LIGHT VALLEY SOLAR DEVELOPMENT CONSENT ORDER

Planning Inspectorate reference EN0110012

Deadline 3 Submission of Mrs Annette Exley

6 October 2026

Rev

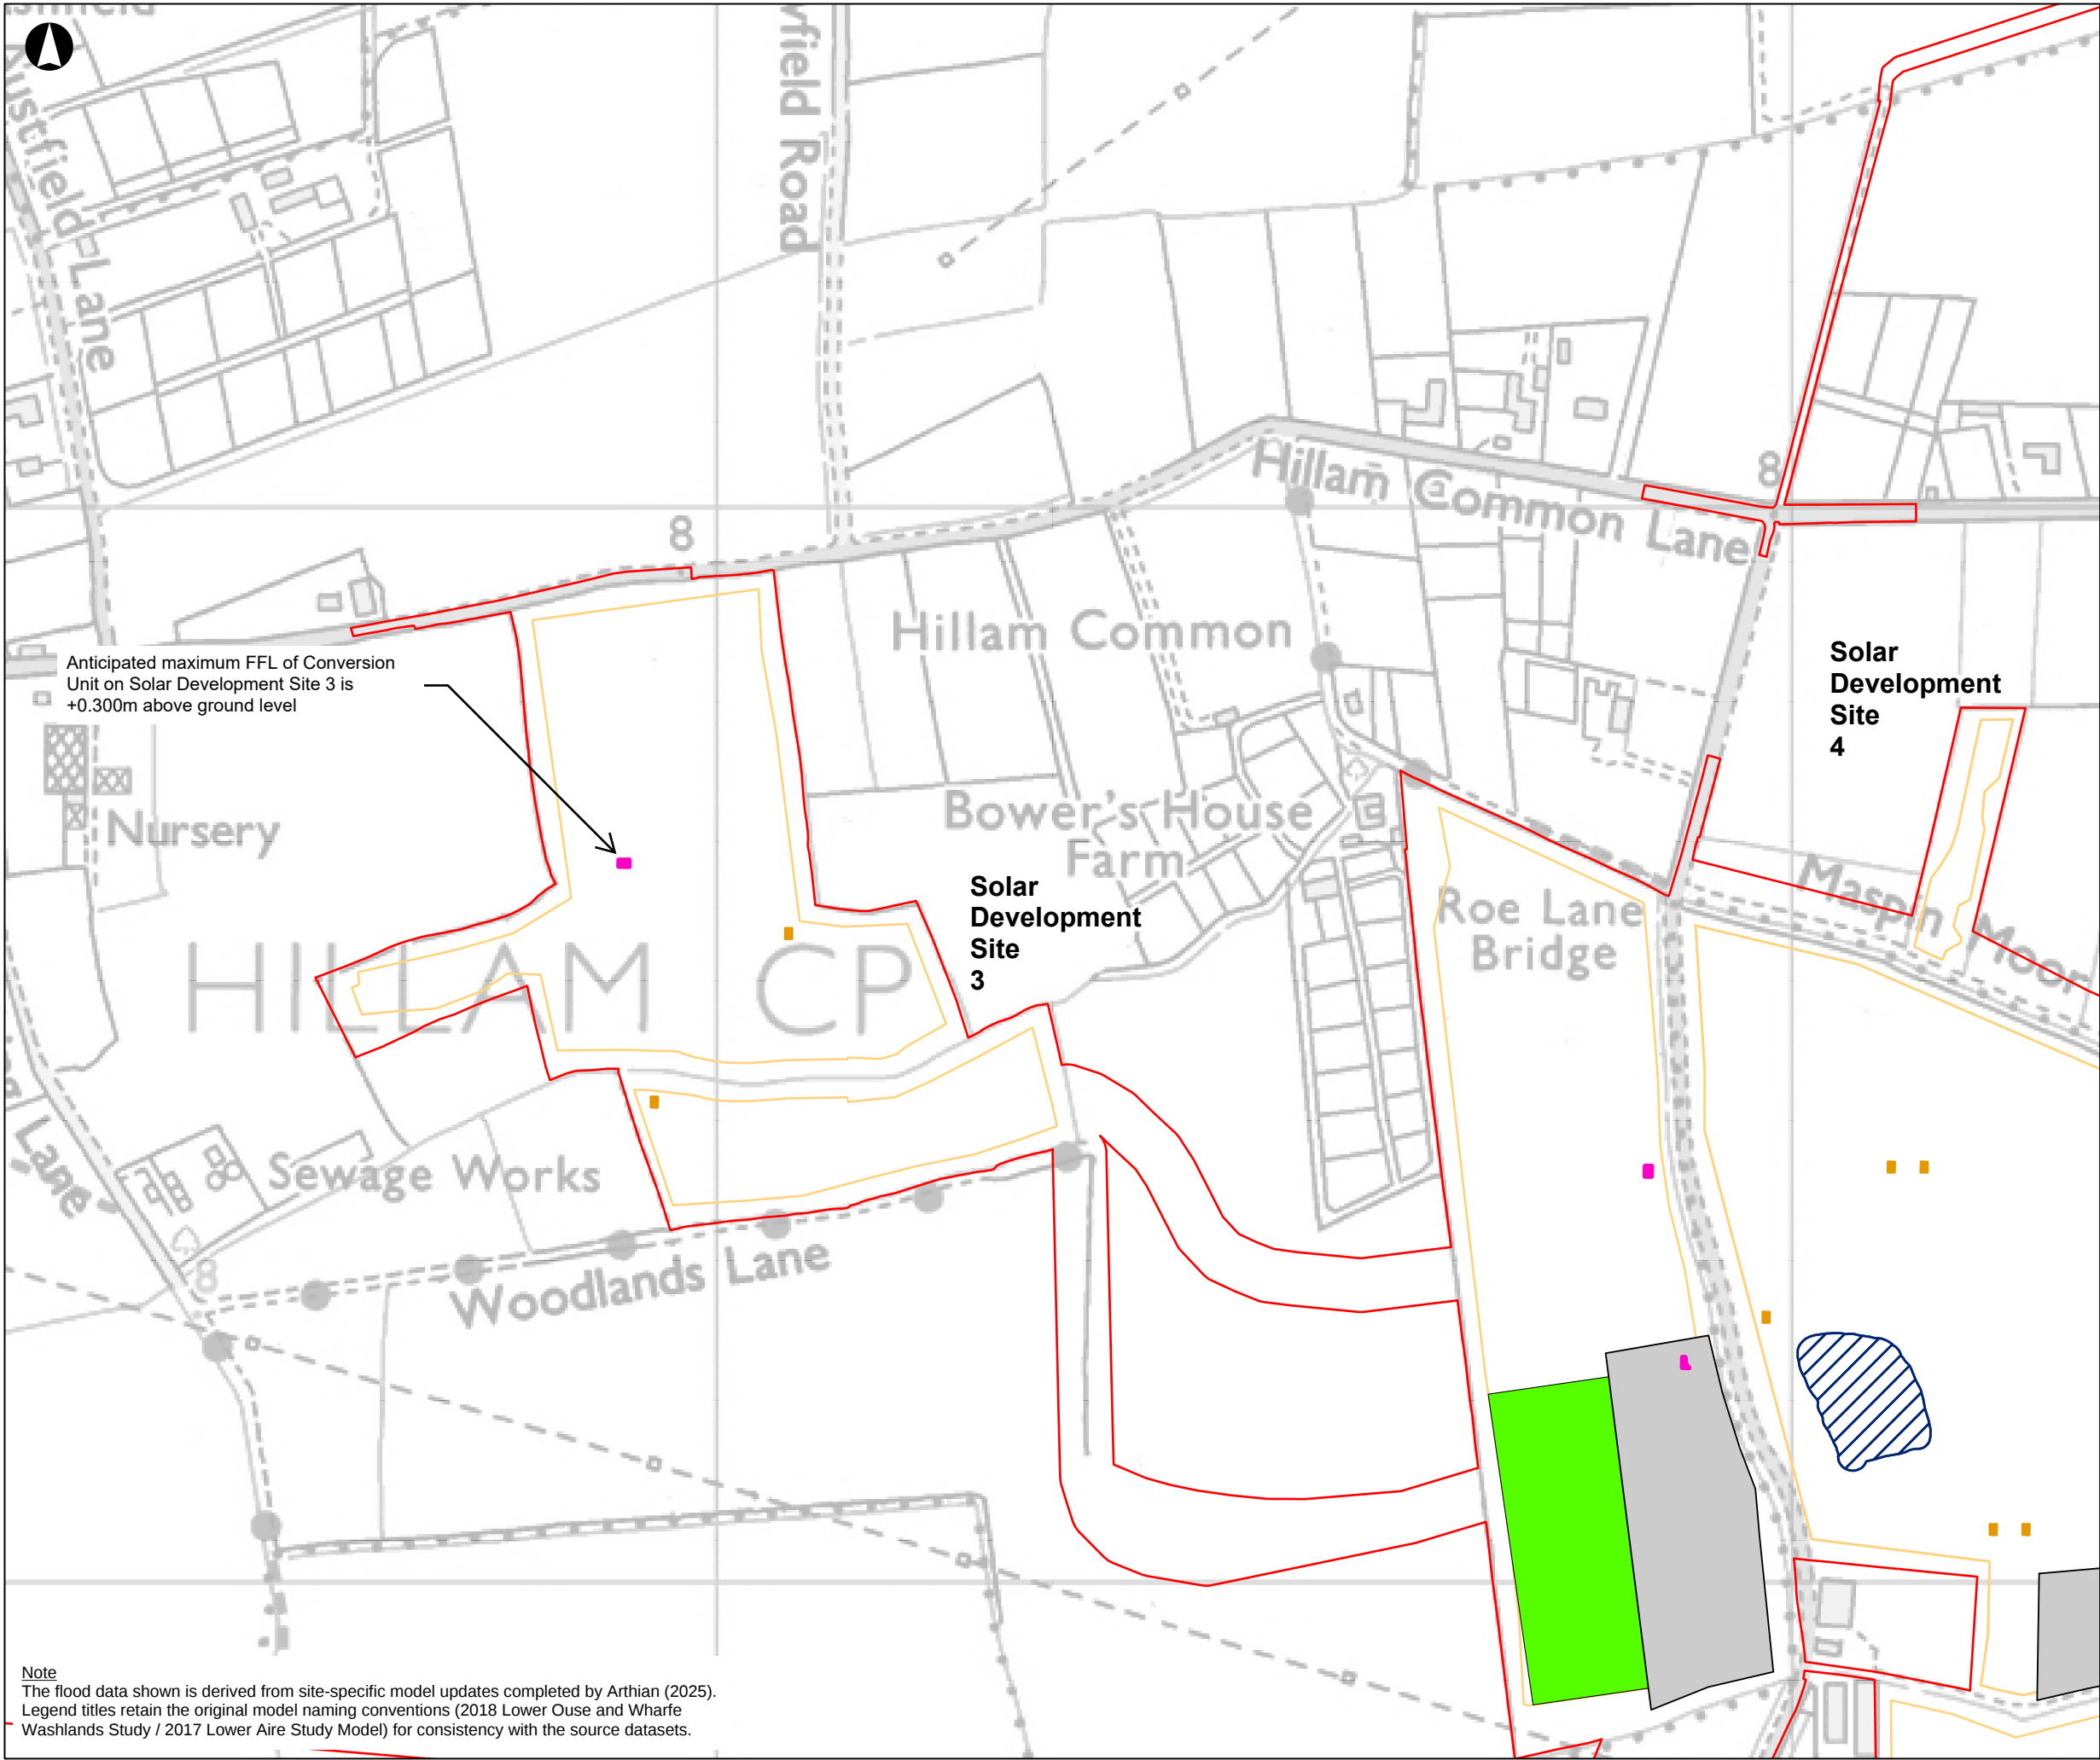
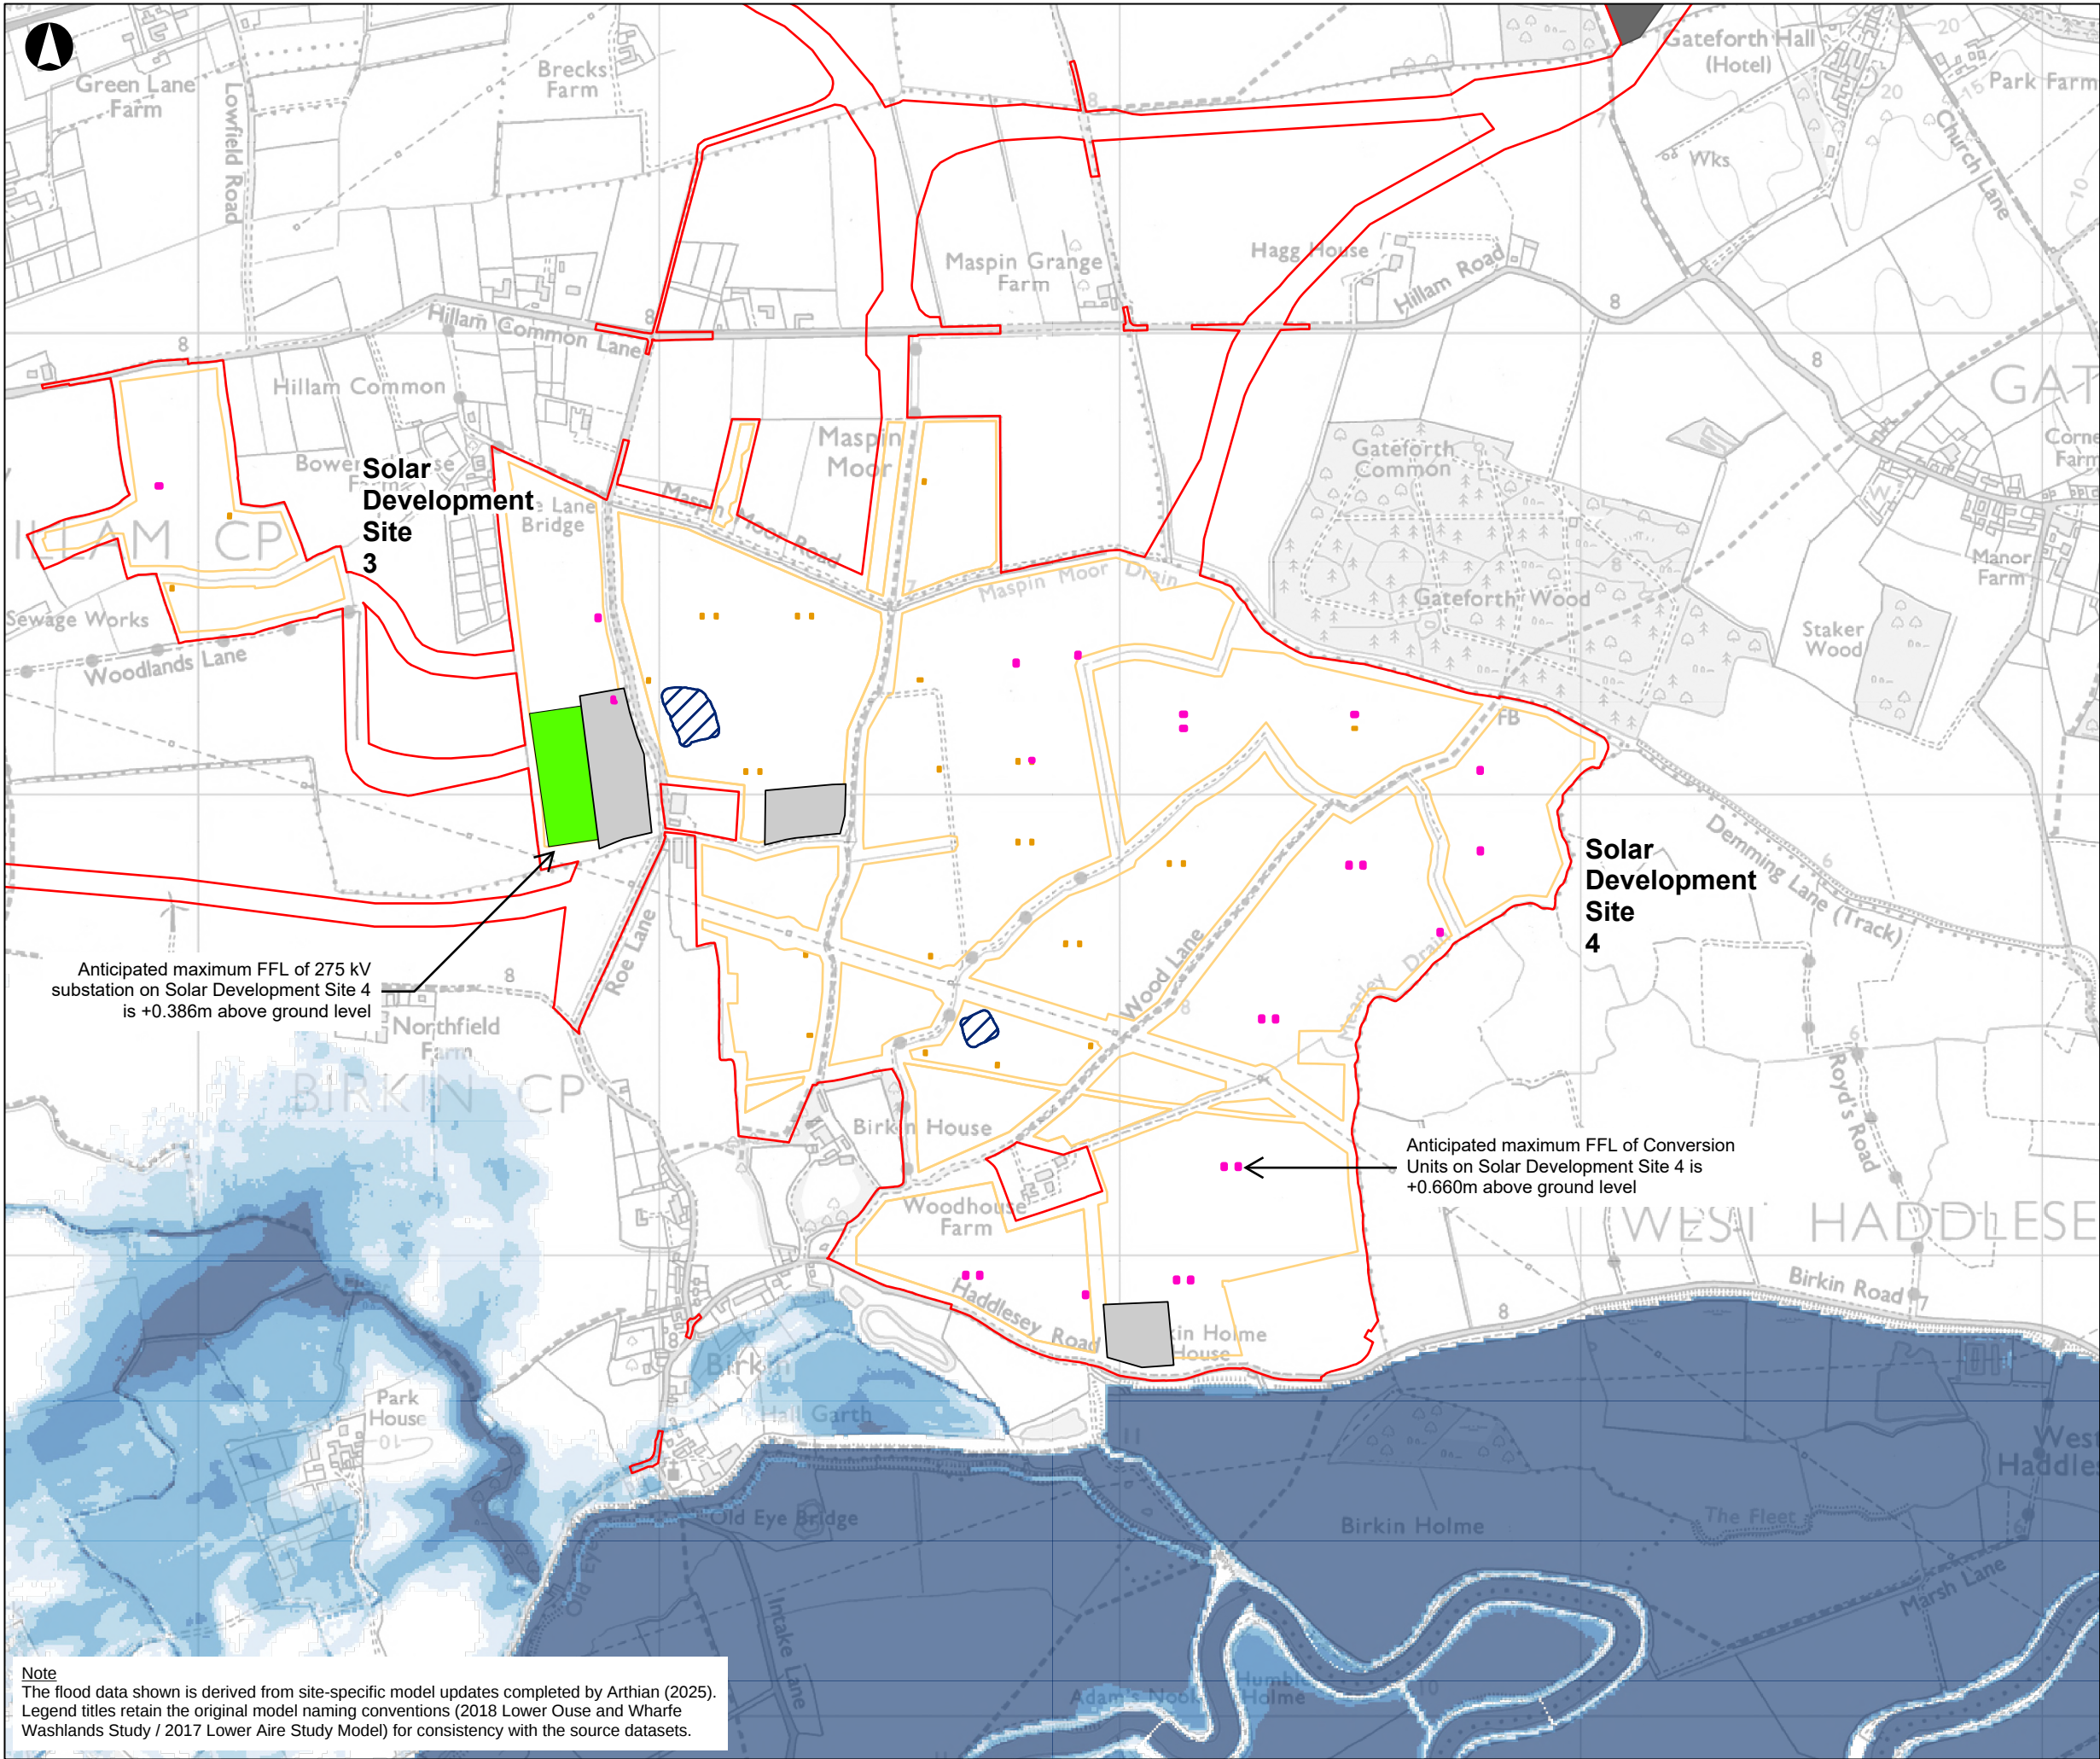
A.18 **[DF]** The anticipated maximum flood depth above ground level at the Solar Development Site 1 conversion units in the **design event** is **+0.5 m**. That figure appears nowhere in ES Volume 1 Chapter 15 [REP2-043], nowhere in Figure 15.27 [AS-041], and nowhere in the Applicant's response at [AS-040].

A.19 **[DF]** Paragraph 8.1.9 of the Flood Risk Assessment states that panels within the design flood extent at Site 1 "will be raised above the modelled design flood level in the corresponding location in accordance with the applicable freeboard parameters or, **where this is not practical**, panel layouts will be refined to avoid flood-affected areas". The same qualification appears on sheet 1 of Figure 15.27. I invite the Examining Authority to consider what secures either limb of that alternative.

B.2.1 **[DF]** The Examination Library records Chapter 15 figures as APP-115 (Figure 15.1) through APP-140 (Figure 15.26), each with an application-stage entry dated 10 February 2026. **There is no application-stage entry for Figure 15.27 or Figure 15.28.** They appear only as AS-041 and AS-042, additional submissions accepted at the discretion of the Examining Authority.

B.2.4 **[DF]** The drawings are stamped revision **P01** — first issue — dated 09/09/2026. The Guide to the Application [AS-038] logs both as "Version 2.0". There is no Version 1.0 of either.

B.2.6 I invite the Examining Authority to require the Applicant to state whether Figures 15.27 and 15.28 form part of the Environmental Statement; if they are to be certified, by what mechanism they are to enter Schedule 13; and why a first-issue drawing has been logged as a second version.

B.2.7 **[DF]** Figure 15.27 is published in six sheets, numbered "Sheet Number 1 of 7" to "Sheet Number 6 of 7". **Sheet 7 of 7 is not published.** The sheet-location index in the corner of all six published sheets shows seven panels. **[RI]** The six published sheets cover all seven solar development sites, which leaves the cable route corridor as the likely subject of the missing sheet — that is, the one location the Applicant now accepts is within functional floodplain. I do not know what sheet 7 shows. I invite the Examining Authority to require its production and to require the Applicant to confirm what it covers.
